Please see responses to City of Mercer Island intake screening comments below as relevant to civil plans:

CIVIL INTAKE COMMENTS

5236 W MERCER WAY
 SINGLE FAMILY RESIDENCE
 TESC PLAN

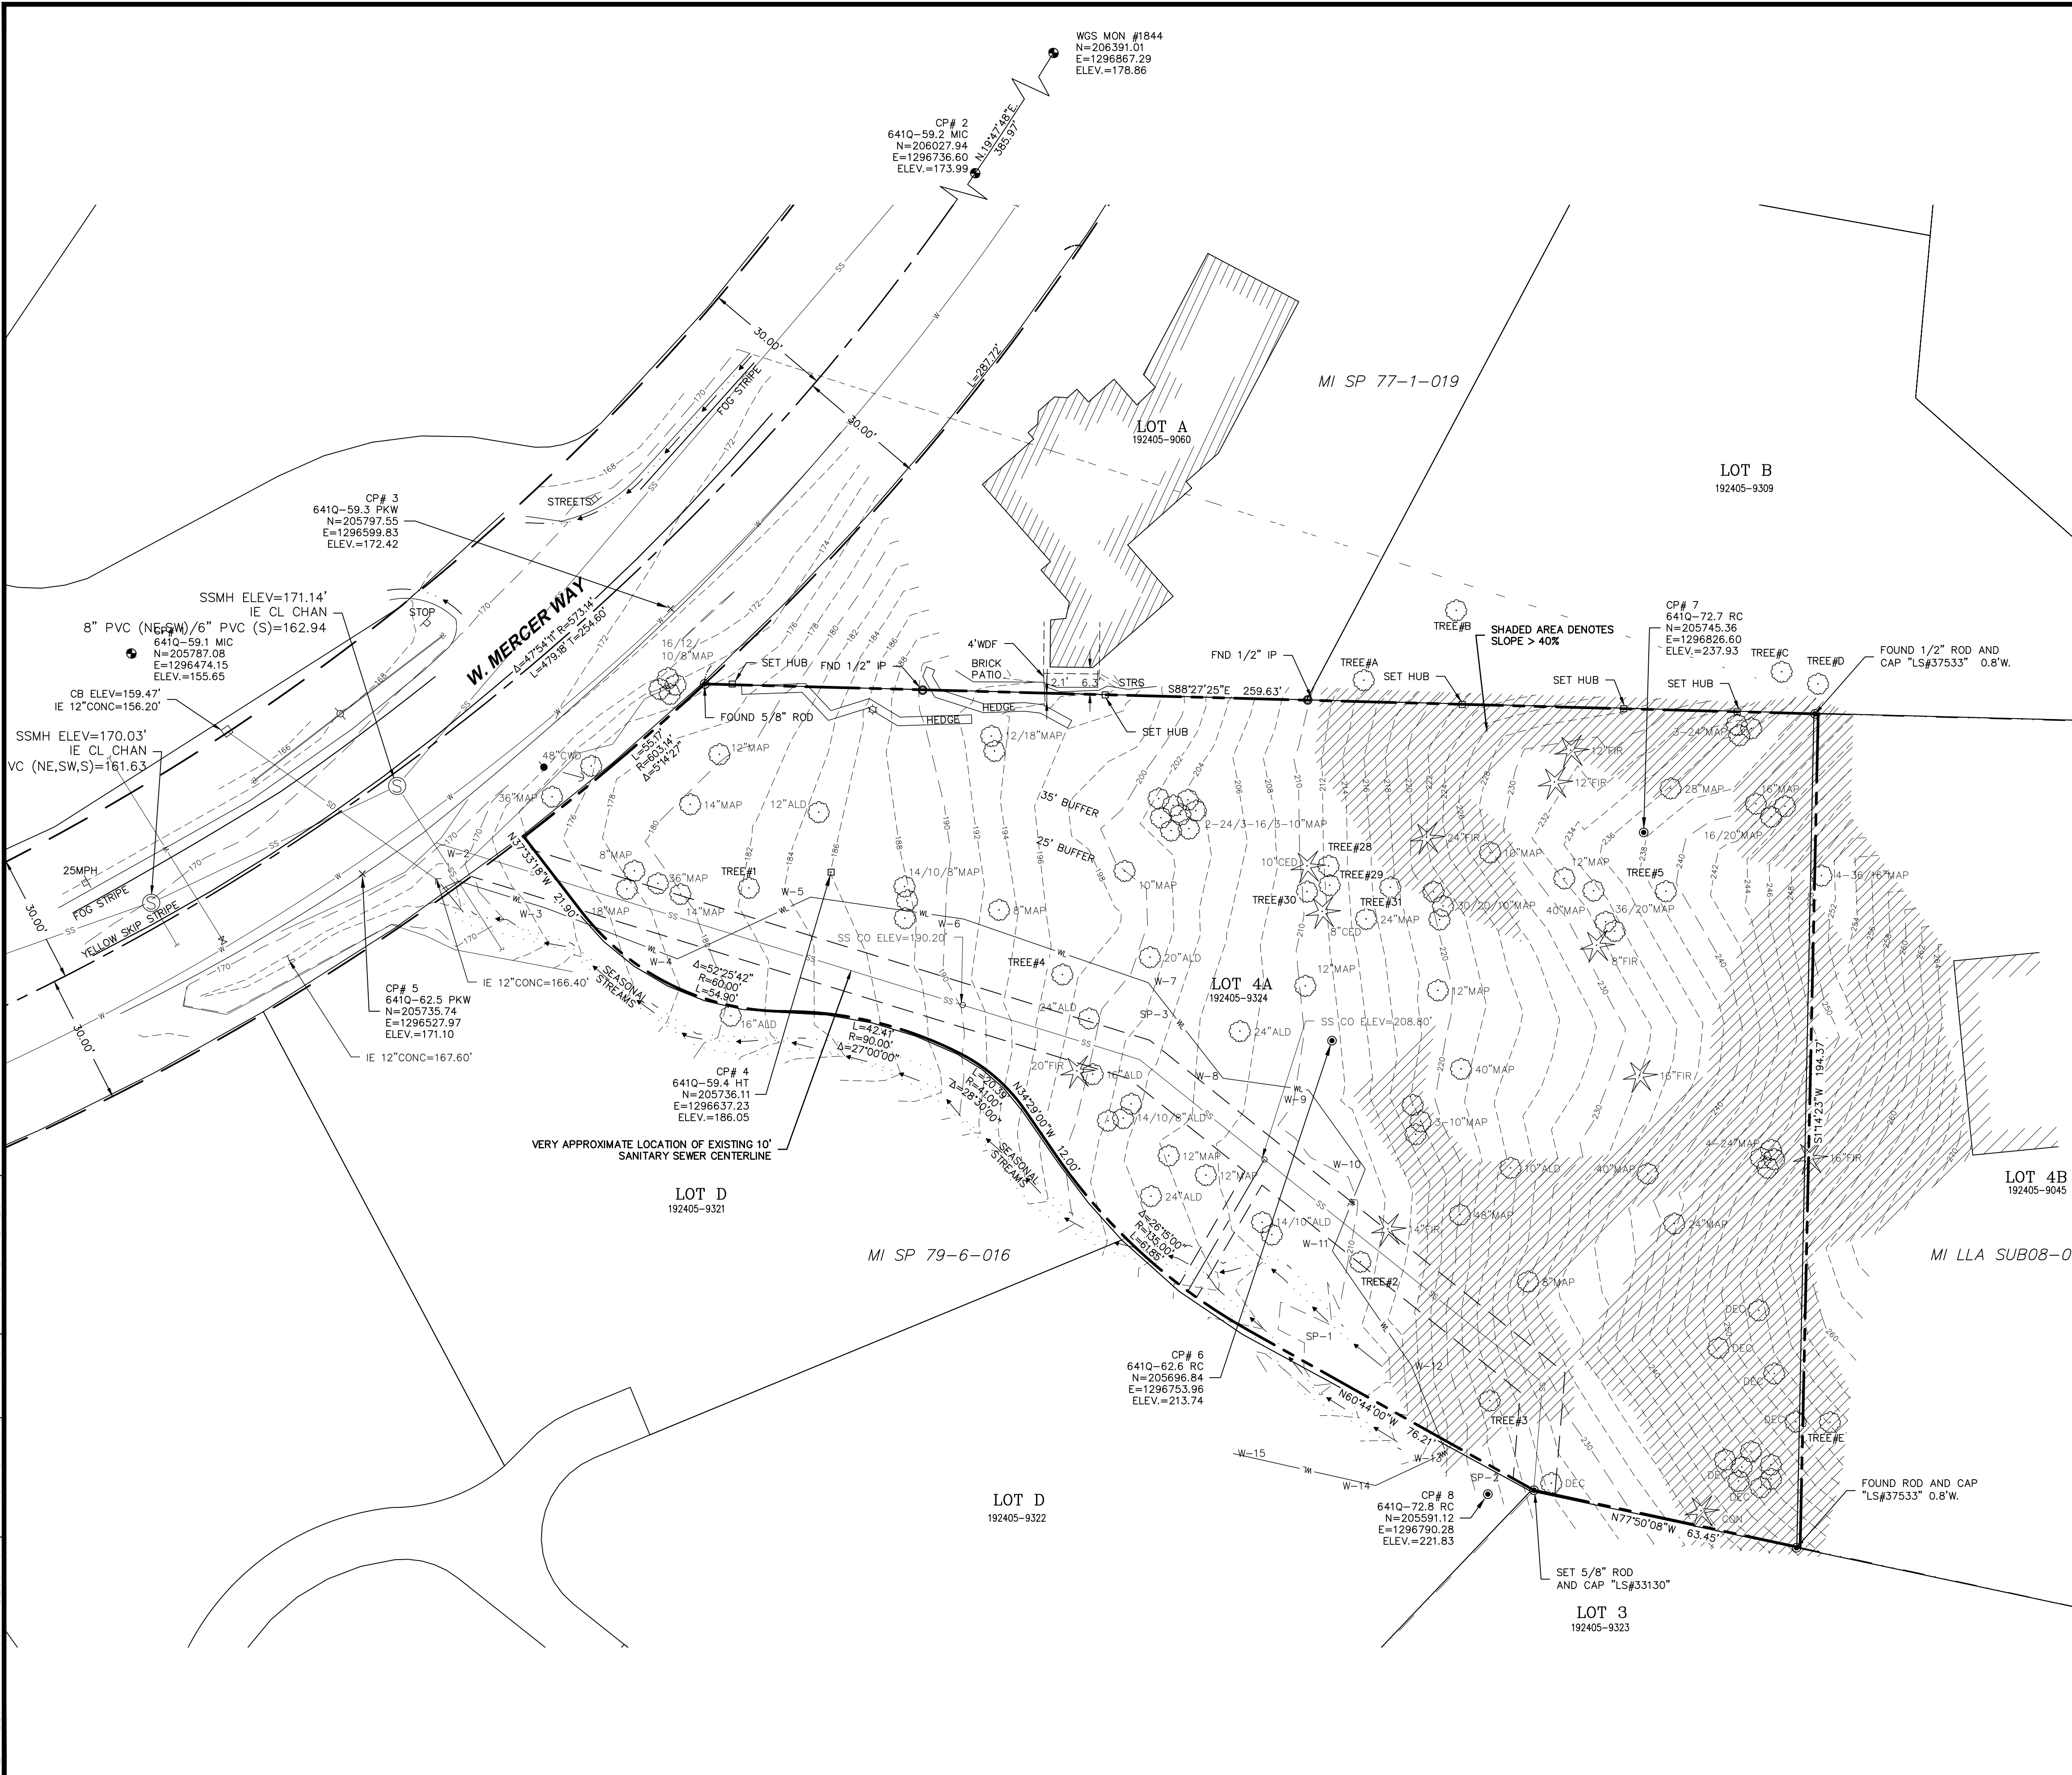
Comment: Indicate the following on the Utility/civil plan sheets – Move silt fence outside tree driplines

Response: Driplines for retained trees are shown on the civil plans. See TESC Plan and Tree Preservation Plan.

Response: Silt fence has been positioned outside of driplines for areas where work is not proposed in driplines.

5236 W MERCER WAY
SINGLE FAMILY RESIDENCE
TREE PRESERVATION PLAN

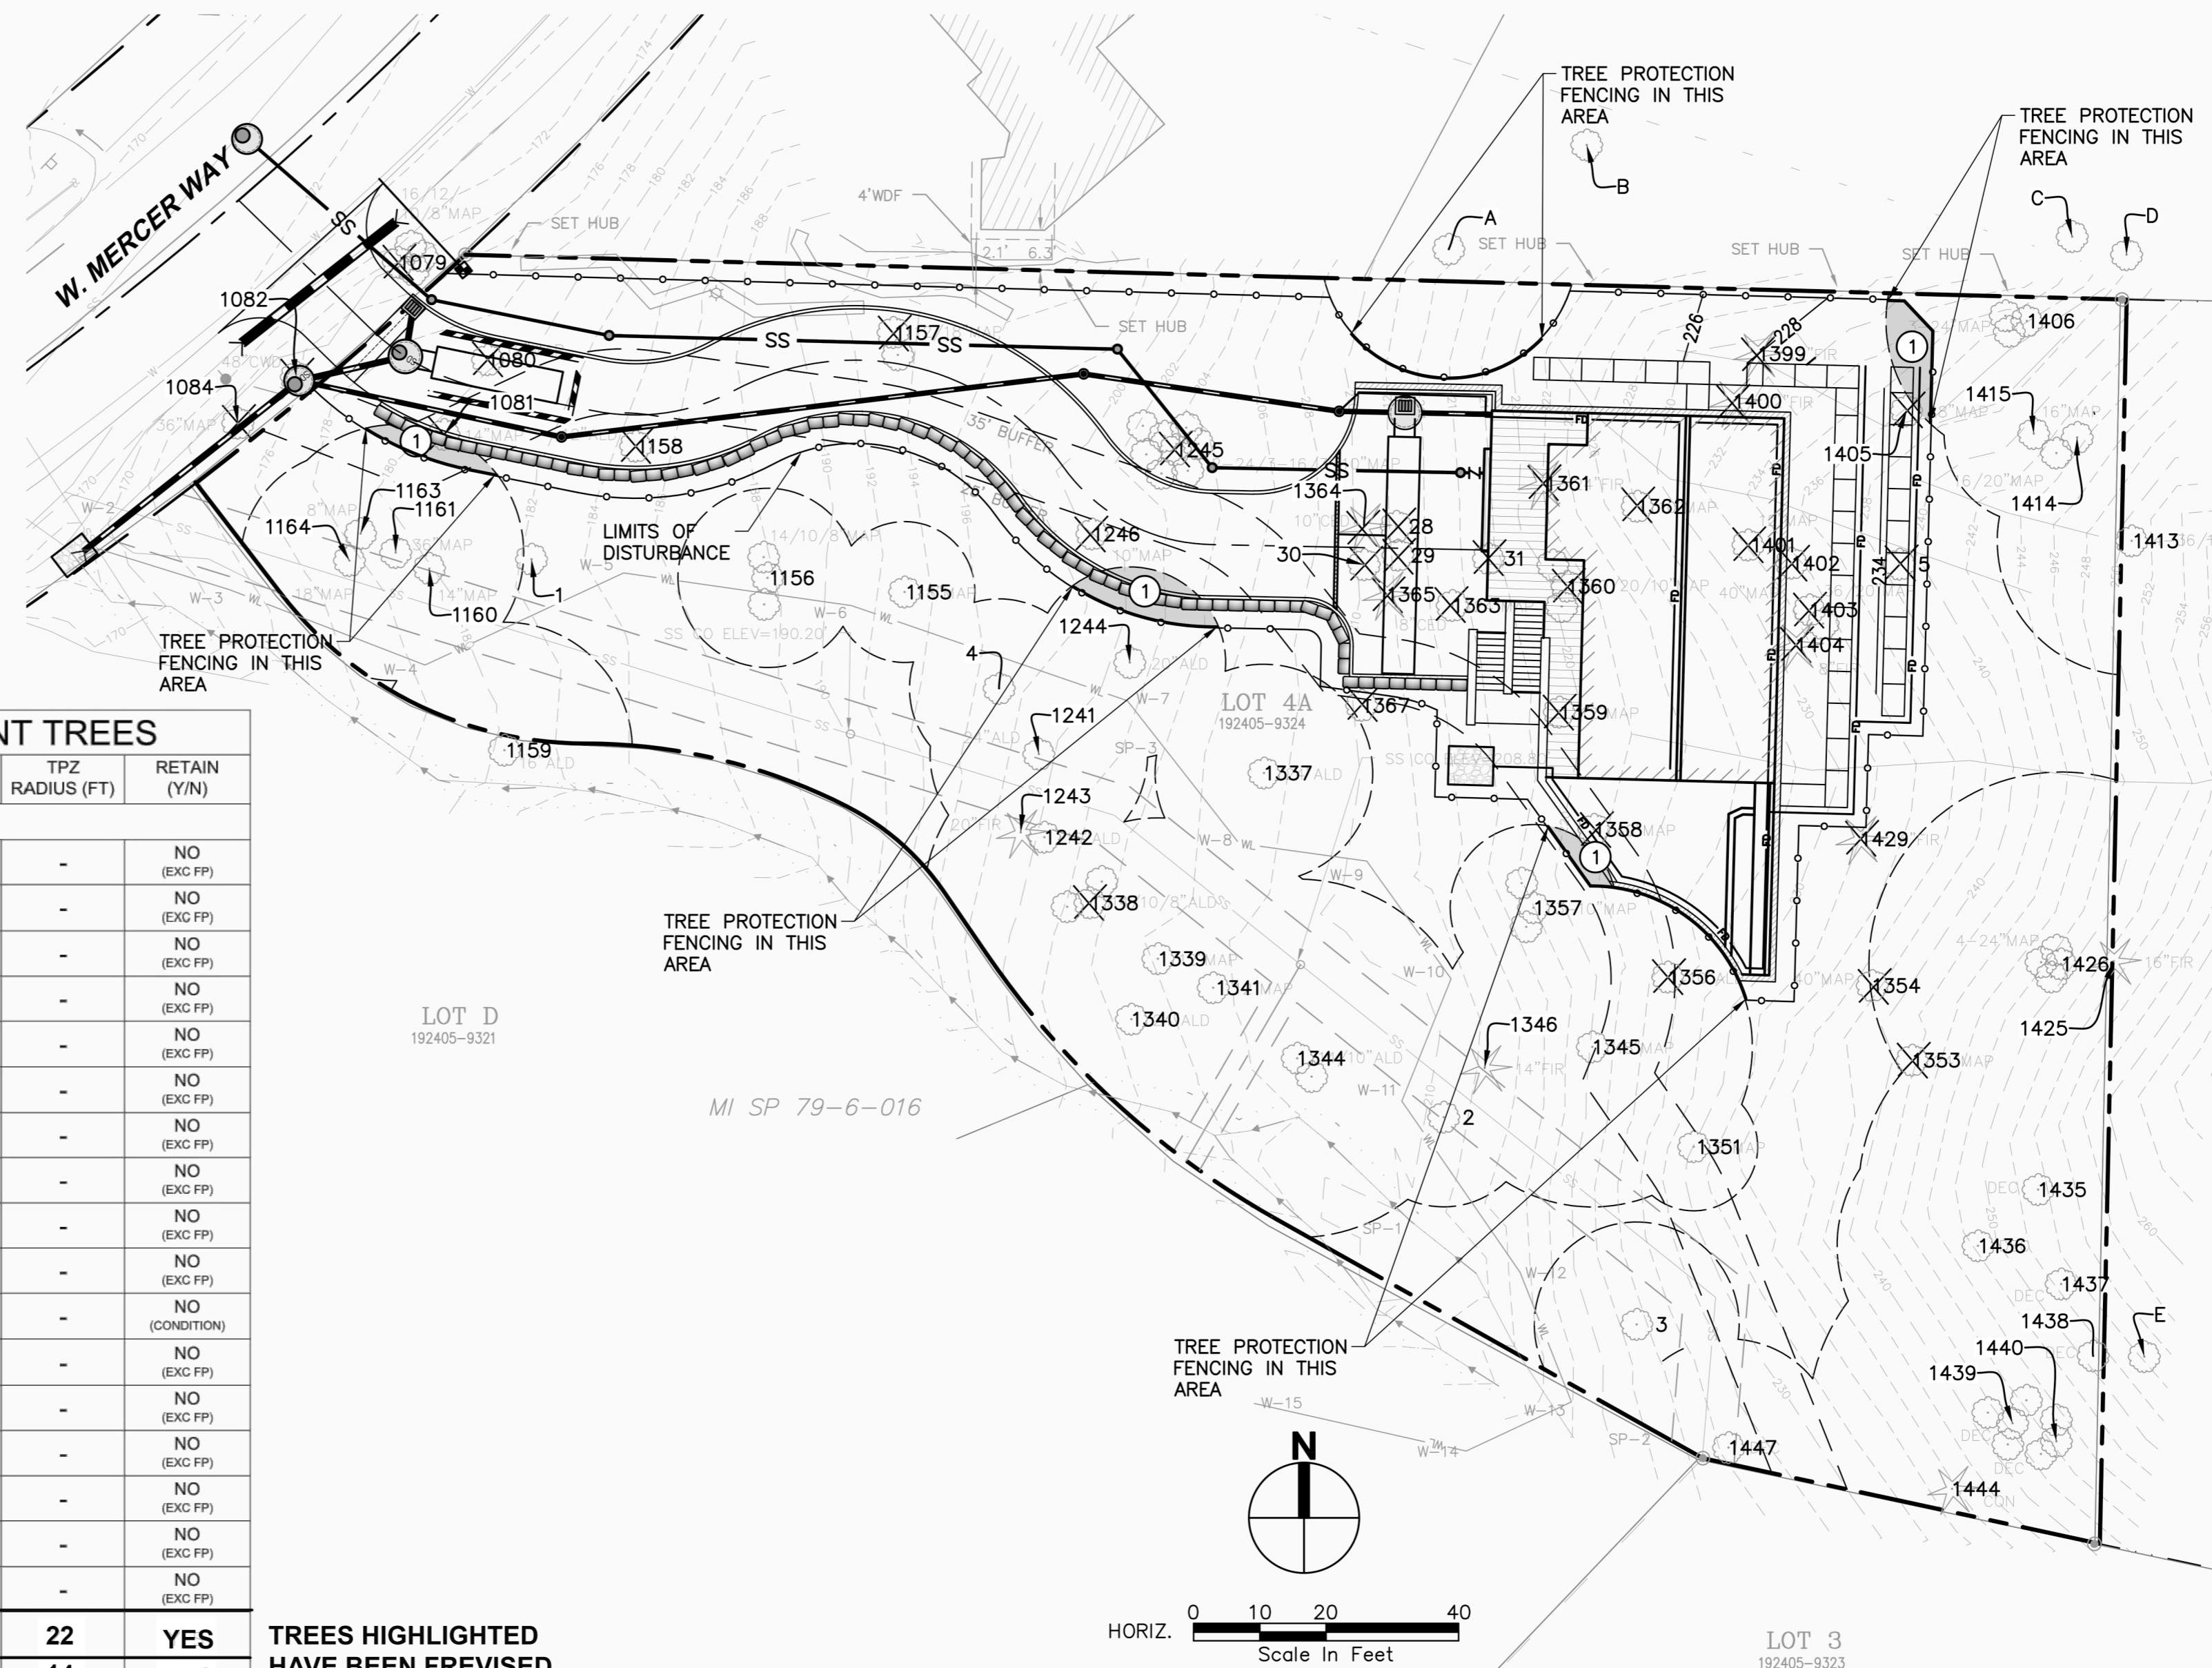
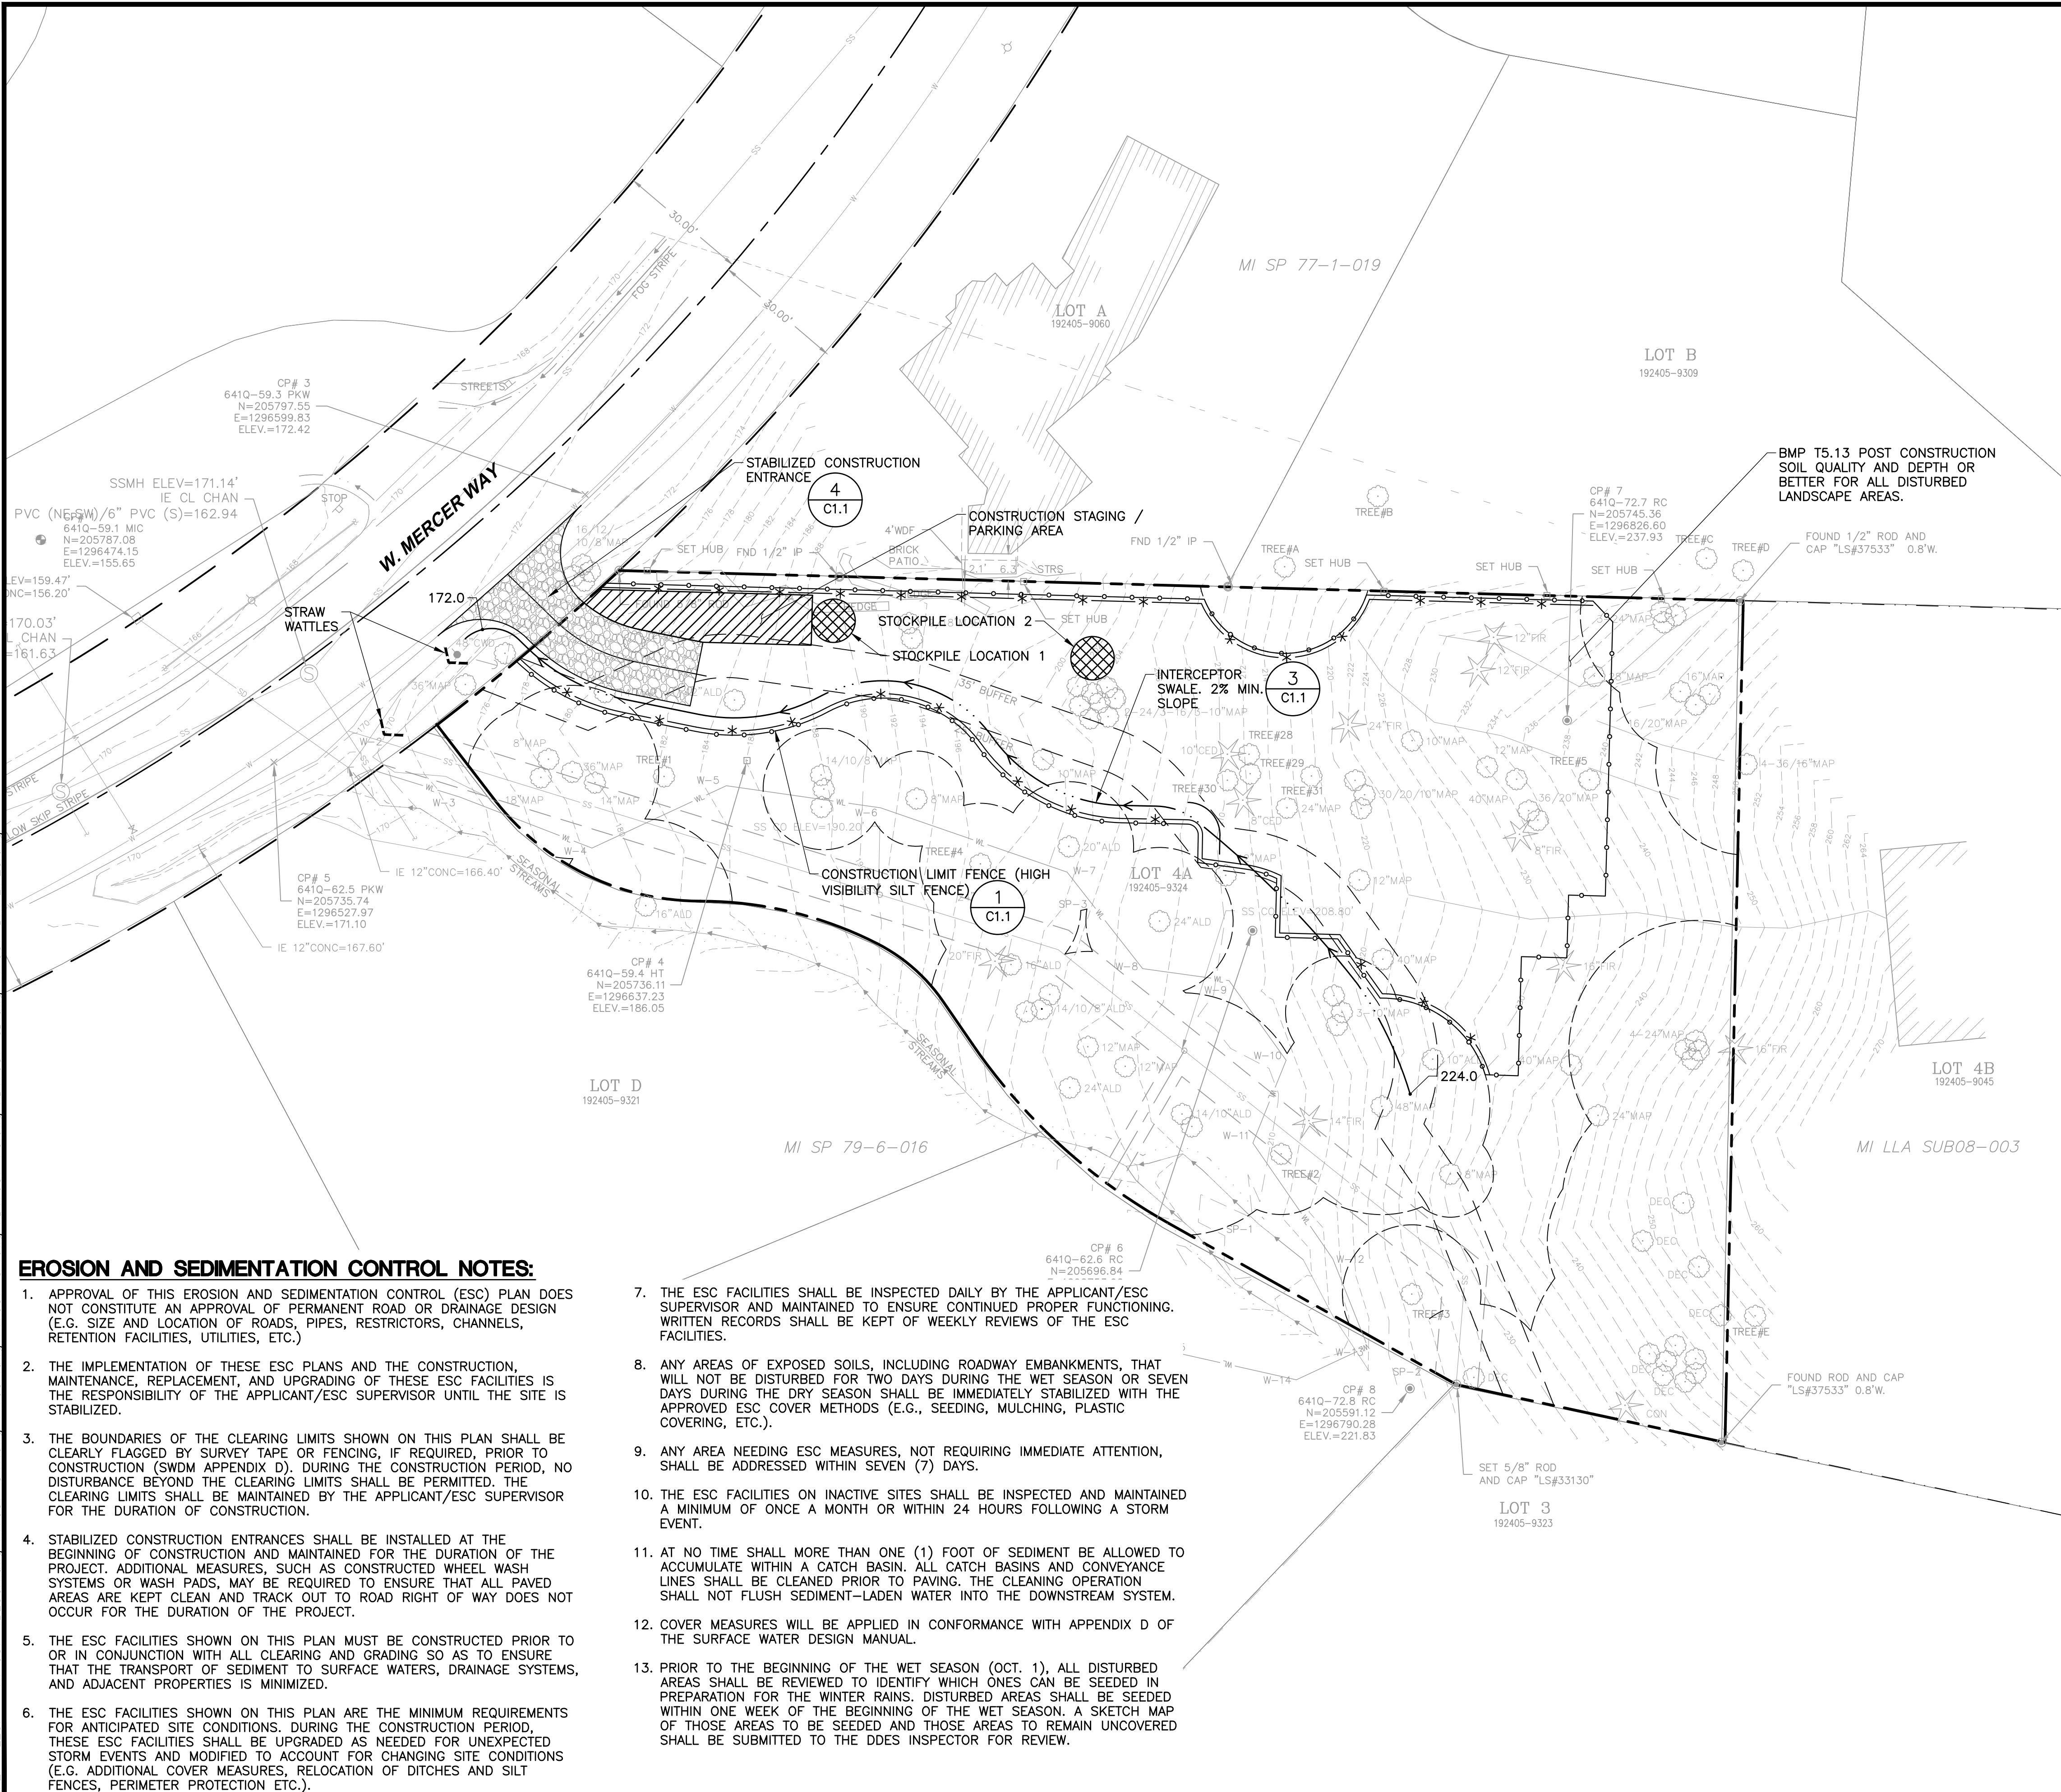
Comment: Indicate the following on the Utility/civil plan sheets – Show drip lines of Regulated Trees to scale

Comment: Indicate the following on the Utility/civil plan sheets – Show tree protection plan for work proposed with drip lines of protected trees

Response: Work in driplines note has been added to civil plans per arborist recommendation. See Keyed Note #1, Tree Preservation Plan.
